EF13/5547, DOC 17/318811-01  
SSD 8126

**SSD 8126 – UNSW CLIFFBROOK CAMPUS RE-DEVELOPMENT – ENVIRONMENTAL IMPACT STATEMENT (EIS)**

#### UNIVERSITY OF NEW SOUTH WALES CLIFFBROOK CAMPUS RE-DEVELOPMENT

title
**General Arrangement Plans
 Lower Ground Floor Plan**

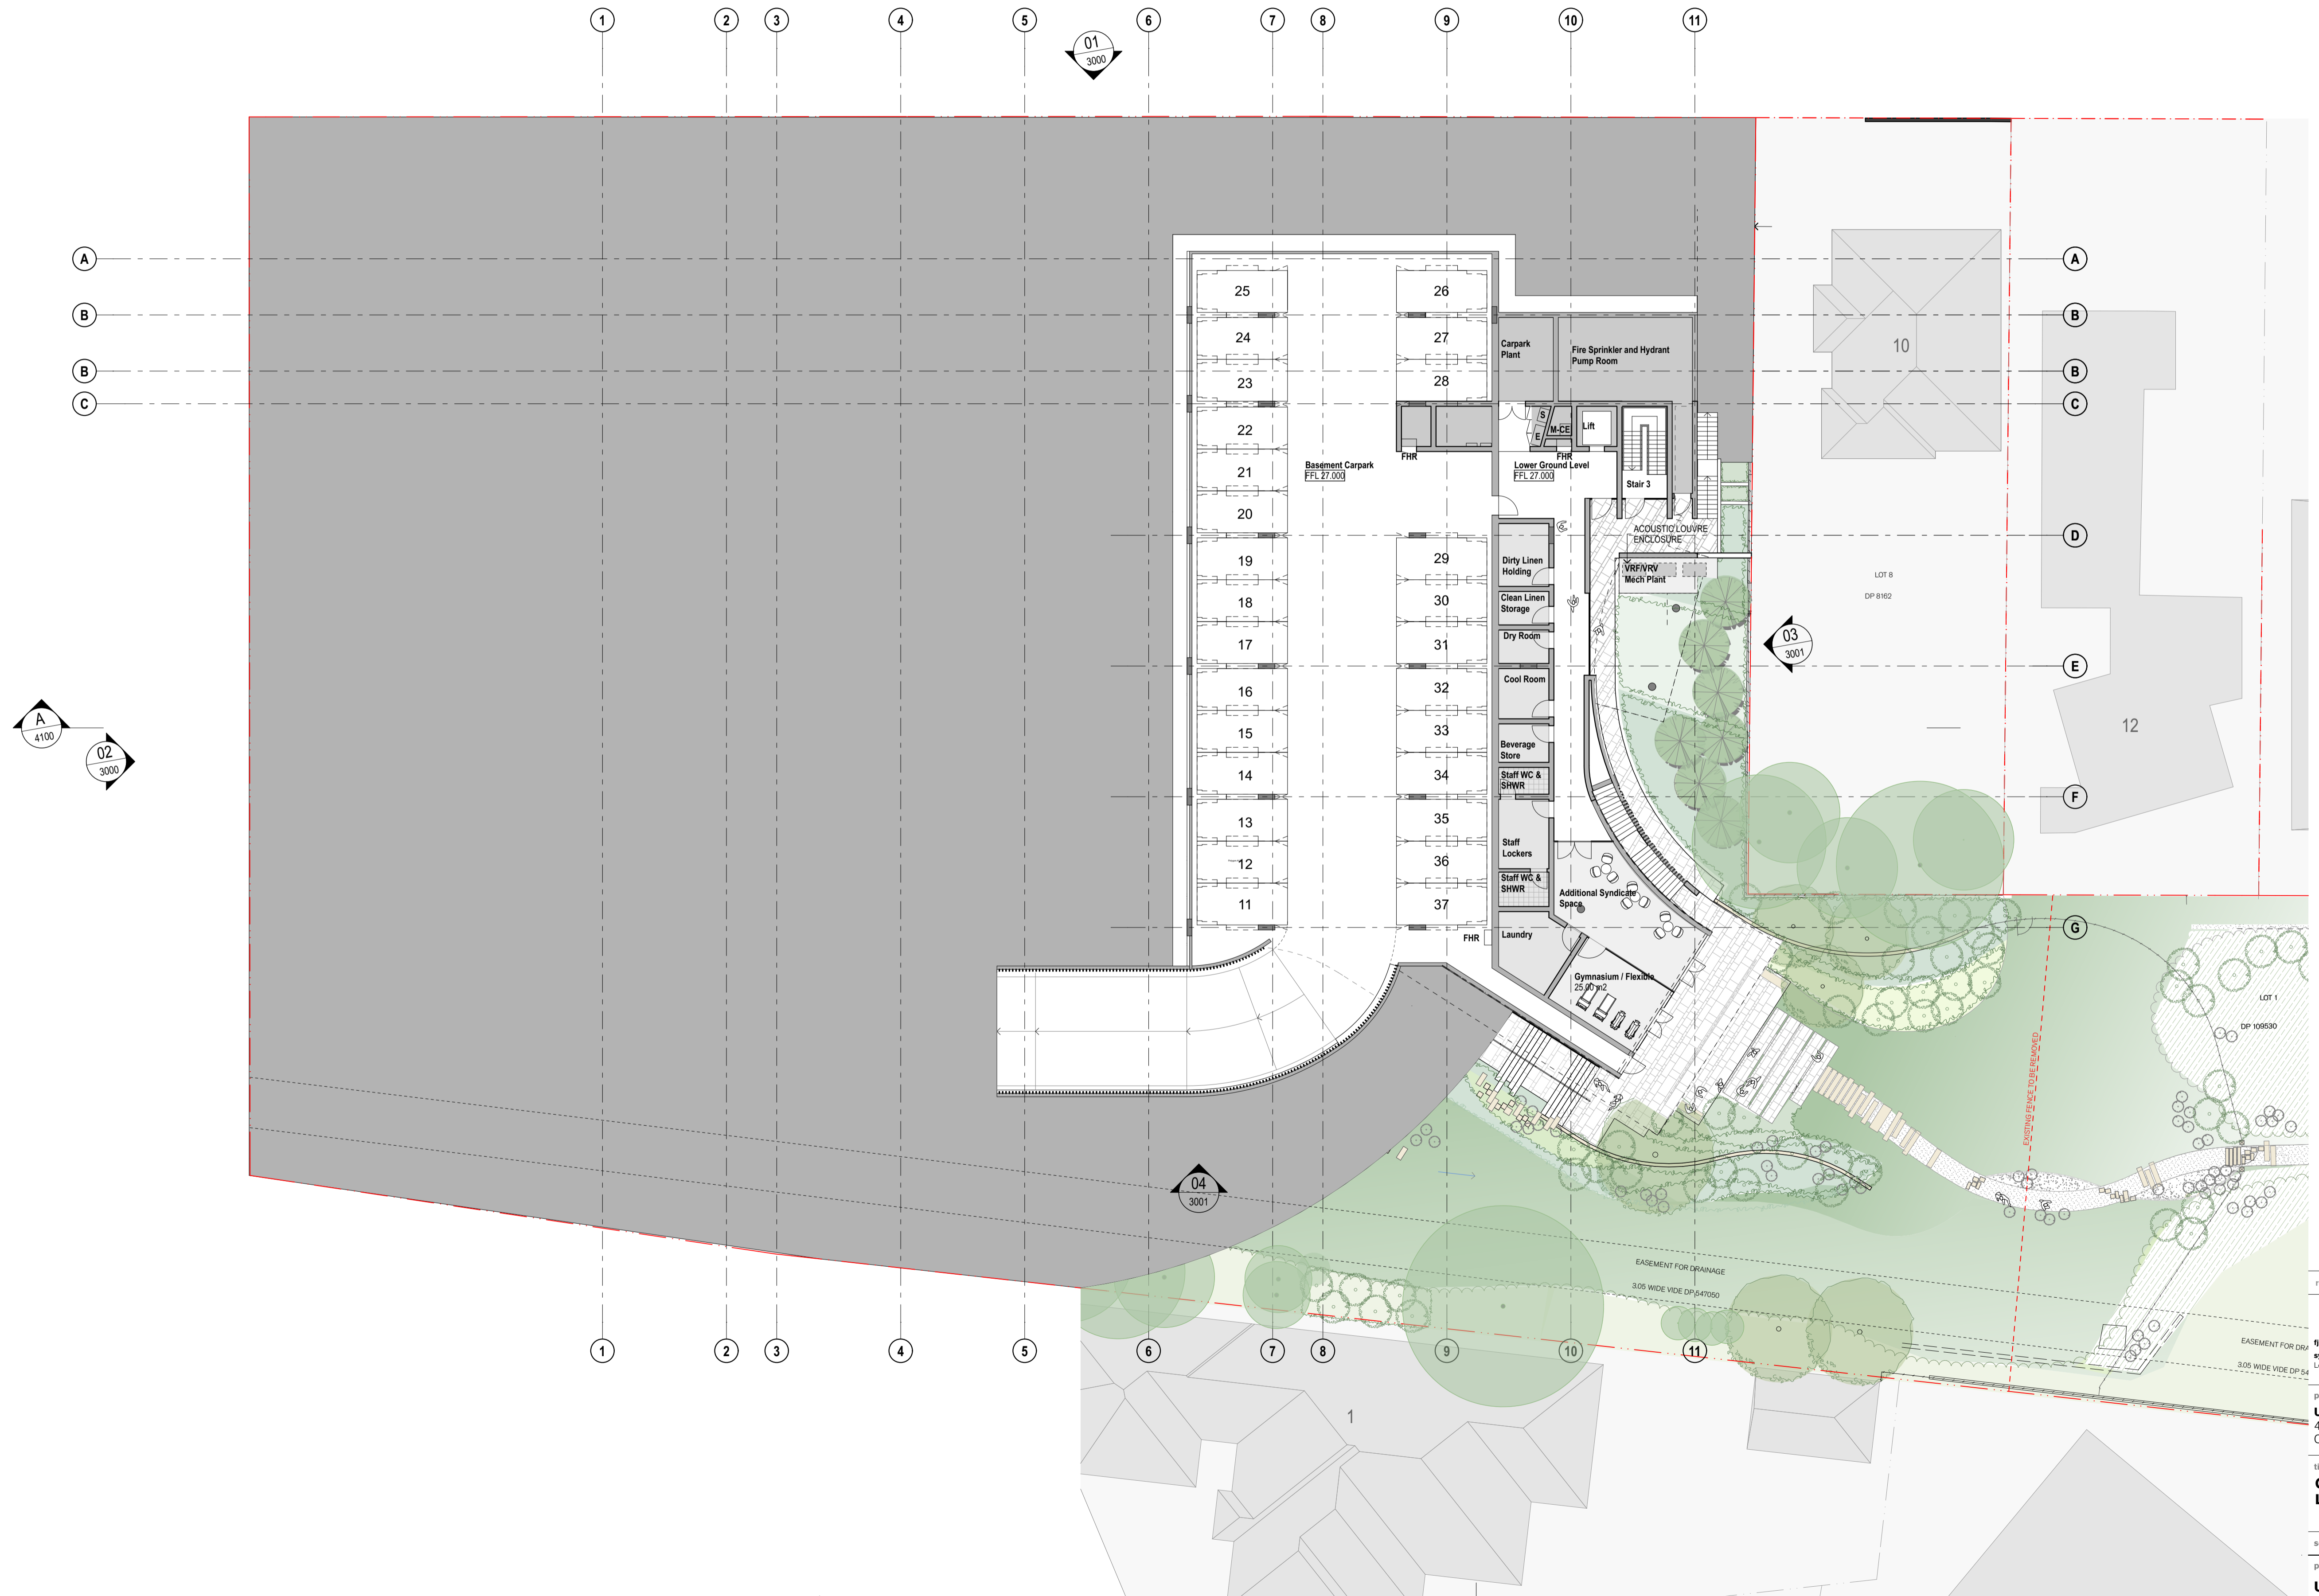
The EPA notes the location of the 'waste' room near the corner of Battery and Beach Streets and the residences opposite.

Waste collection services have been a source of community concern at other universities when those services are rendered other than between 7.30 and 6.00 pm on weekdays.

The proponent be required ensure waste collection services are not undertaken outside the hours of 7.30 am to 6.00 pm Monday to Friday.
